EN010117: Application by Rampion Extension Limited for the Rampion 2 Offshore Wind Farm

Horsham District Council response to The Examining Authority's further Written Questions and requests for information issued on 18th June 2024

Deadline 5: HDC Response and Information Requested to the Examining Authority's further written questions and requests for information [PD-012].

**Key to Phasing of Planting**

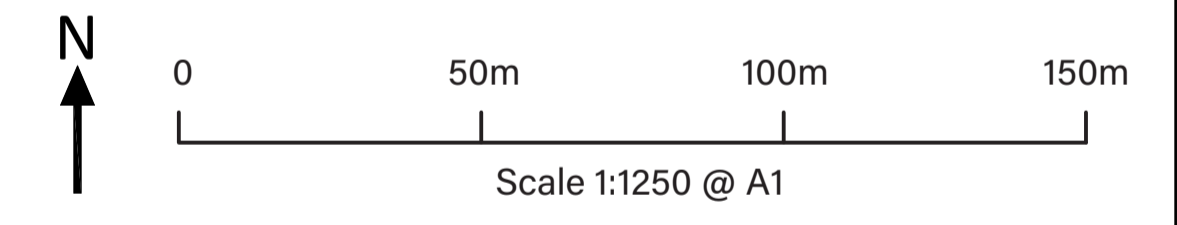
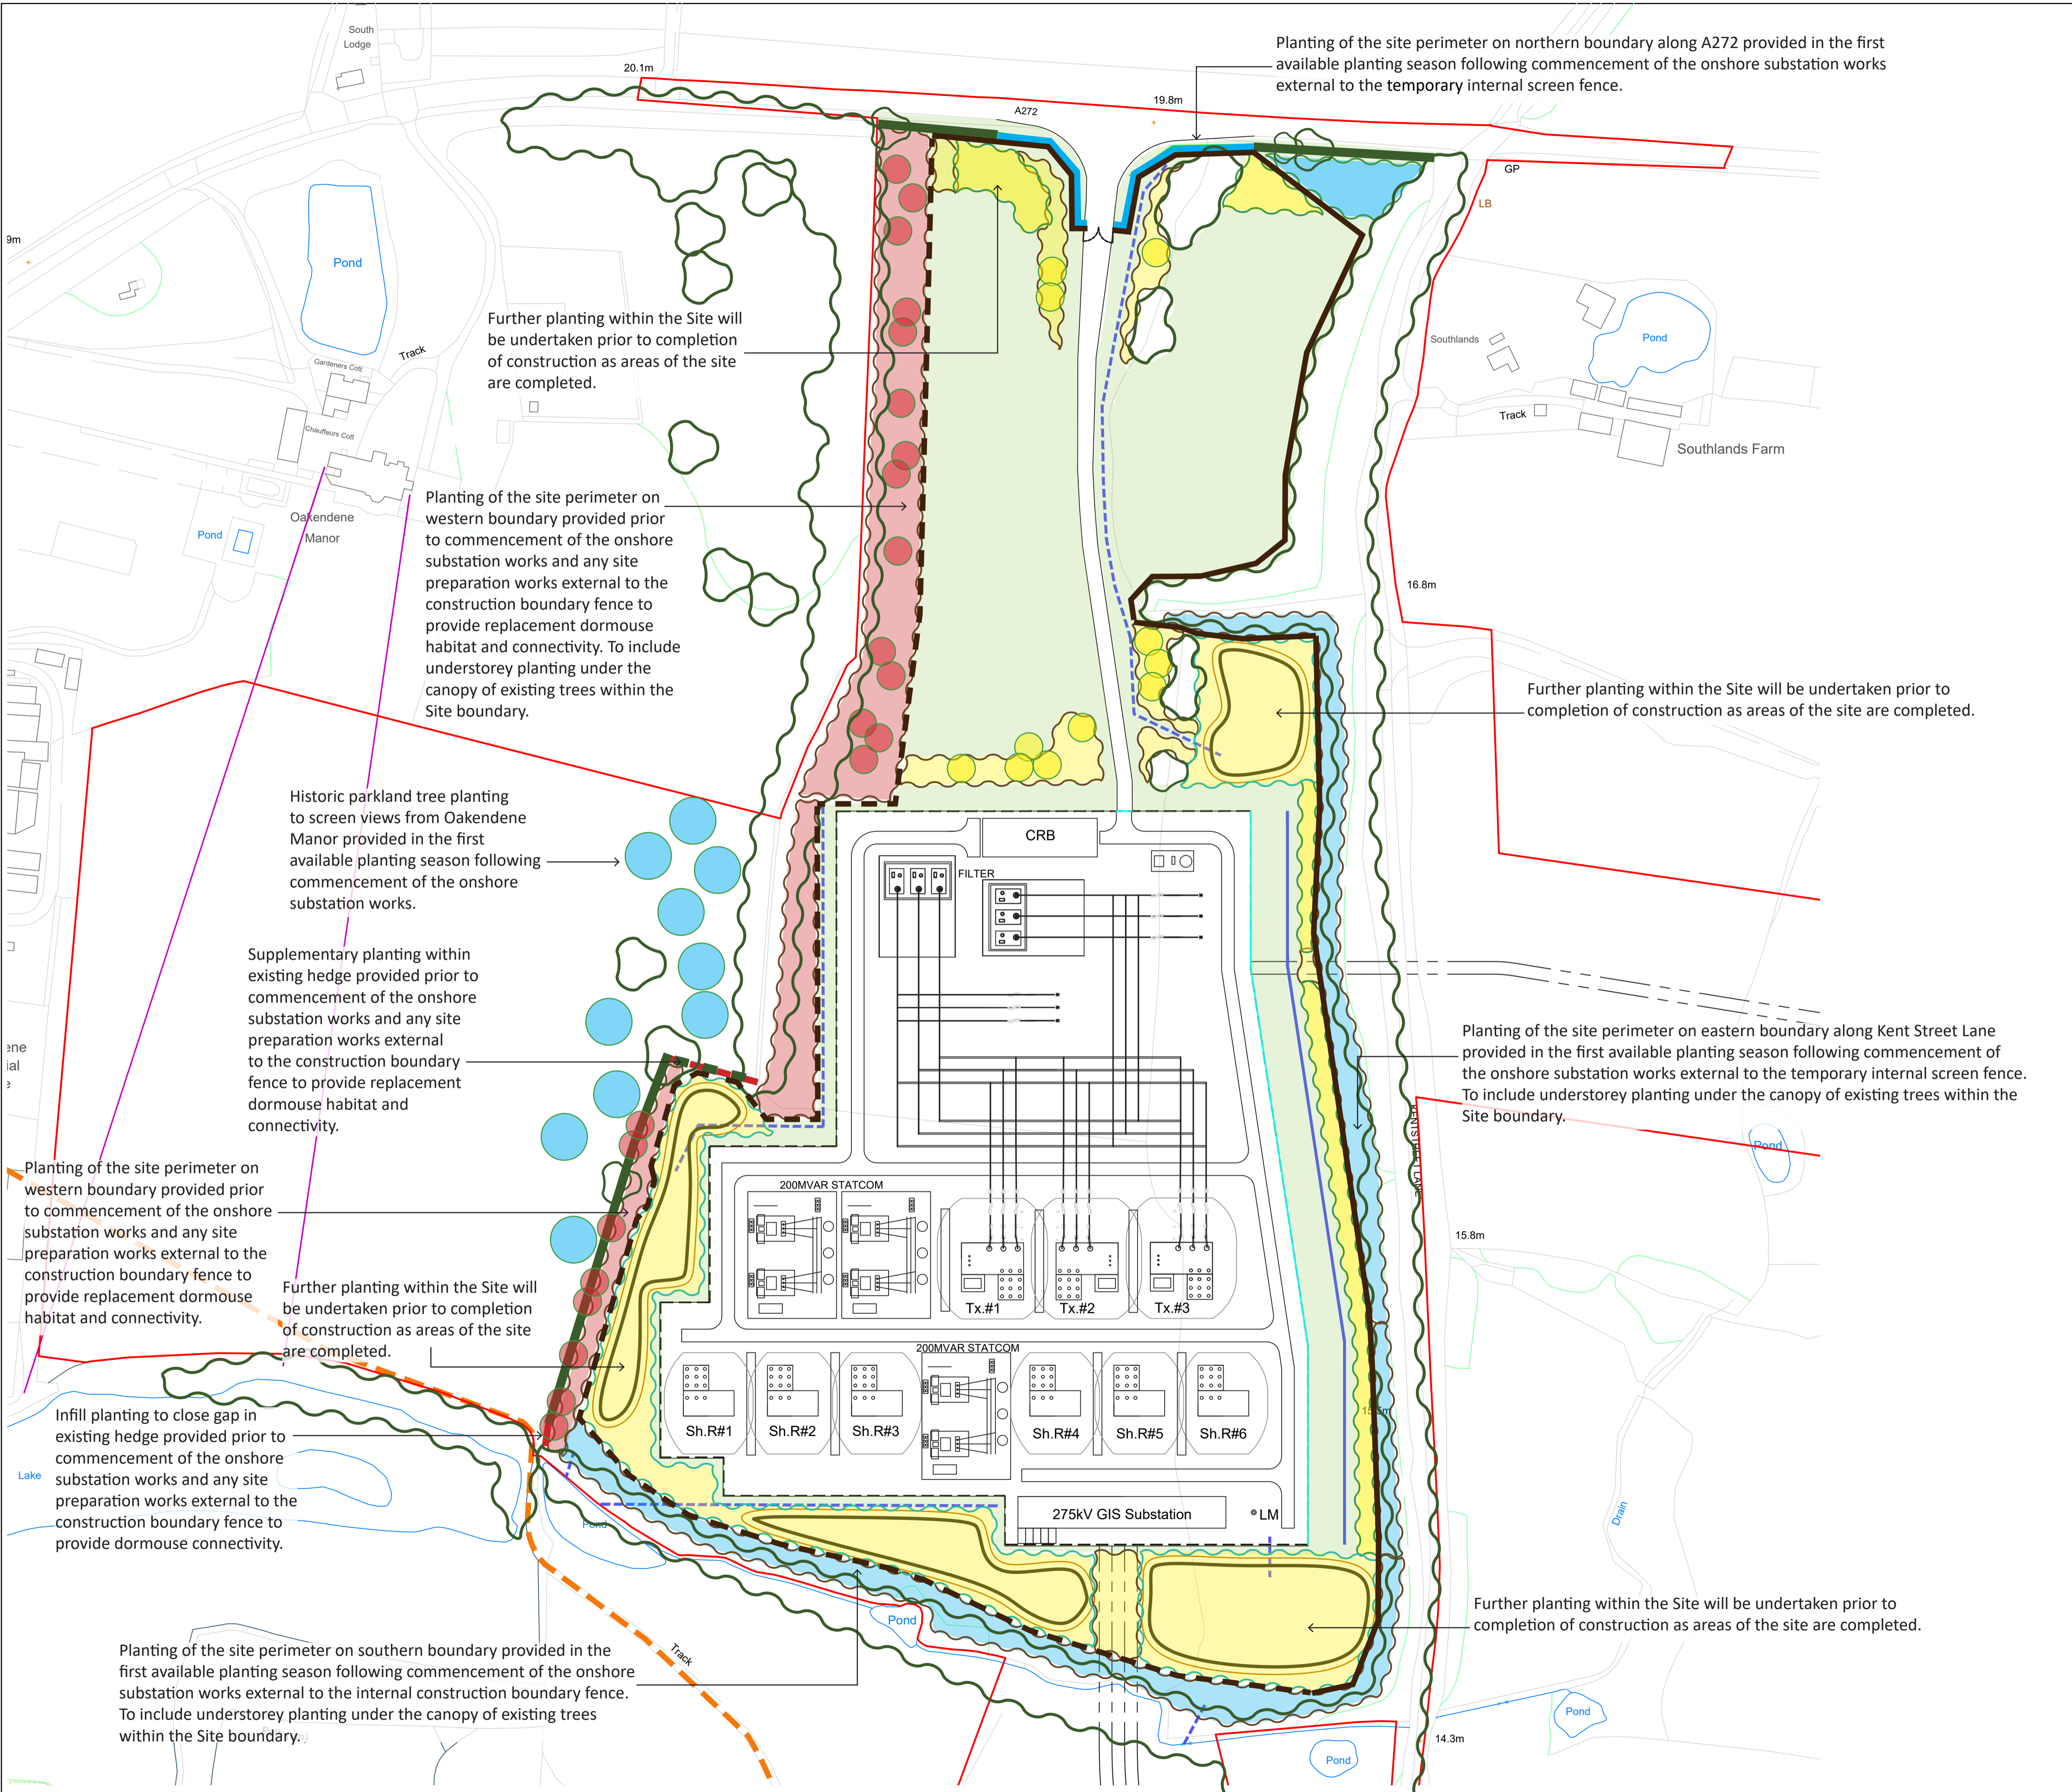
Plan Relevant Planning Authorities	All	<p>Applicant at Deadline 4 [REP4-047]. If so, explain these in as much detail as possible.</p>	<p>HDC notes from the Indicative planting phase plan that the planting area denoted in the colour blue with the key to Phasing of Planting referring to 'first available planting season following commencement of the onshore substation works', includes areas to be planted beyond the site's temporary perimeter fencing (described in various ways as internal screen fence to eastern boundary/ internal construction fence to southern boundary/construction boundary fence to western boundary/temporary internal screen fence to northern boundary).</p> <p>One of the first tasks to be carried out when setting up a construction site is to erect the perimeter fencing to make a site secure (it is assumed that this is the fencing that is being referred to in differing ways on the plan and clarification on this is requested with the wording of the plan amended). Planting the area denoted in blue after the fence is erected is not practical and likely to result in poor delivery, longer planting times as access will be partially constrained and limited for maintenance purpose only.</p> <p>Assuming all references on the planting phase plan relate to the same perimeter fencing, it is understood the western boundary is to be planted prior to commencement of the onshore substation works which will have to take place within the appropriate planting season. All areas identified in blue, save for the formation of the site access, are adjacent to existing vegetation and no ground works are to take place other than planting and the erection of the perimeter fencing therefore, the need to leave the area to be planted until the first planting season available is queried. It is recommended that these areas also come forward as advance planting and the wording on the Indicative planting phasing plan 42285-WSPE-EX-ON-FG-OL-3902 updated to reflect this.</p> <p>HDC recommended wording as follows: <i>'First available planting season prior to the erection of perimeter fencing'.</i> It is also recommended that the key includes the following wording: <i>Temporary close board fence to have access points suitable for maintenance of the landscaped areas.</i></p>

<p>These necessary amendments to the indicative planting phasing plan 42285-WSPE-EX-ON-FG-OL-3902 would satisfy HDC that the buffer zones, which are a key mitigation to the LVIA assessed mitigation strategy is delivered in a timely manner and maintained successfully.</p> <p>Alongside amendment to the phasing plan, HDC strongly supports item 8 of ExA's Proposed changes to the draft DCO which has recommended provision of an overarching site-specific plan for Oakendene prior to works commencement, to address, amongst other things, HDC's ongoing concerns regarding feasibility on habitat creation and its establishment and long-term survival (whether this is wet or dry woodland), and demonstrating how drainage will work with landscaping to deliver the necessary mitigation.</p>
TE 2.28	New Requirement 40 Regarding the Vegetation Retention and Removal Plan All Relevant Planning Authorities Statutory Nature Conservation Bodies	<p>a) Comment on the adequacy of the newly added Requirement 40 from the Applicant at Deadline 4 (Schedule 1, Requirements 40) in Revision E of the Draft Development Consent Order [REP4-004] which secures Vegetation Retention and Removal Plan must be in line with the Outline Vegetation Retention and Removal Plan (to be submitted at D5).</p> <p>b) The ExA requests that all relevant Planning Authorities and SNCBs provide comments at Deadline 6 on the Outline Vegetation Retention and Removal Plans to be submitted by the Applicant at Deadline 5.</p>	<p>a) HDC is satisfied with the adequacy of the newly added Requirement 40 and further control it gives to check any anomalies with the outline plans.</p> <p>b) HDC confirms comments to be provided at deadline 6</p>
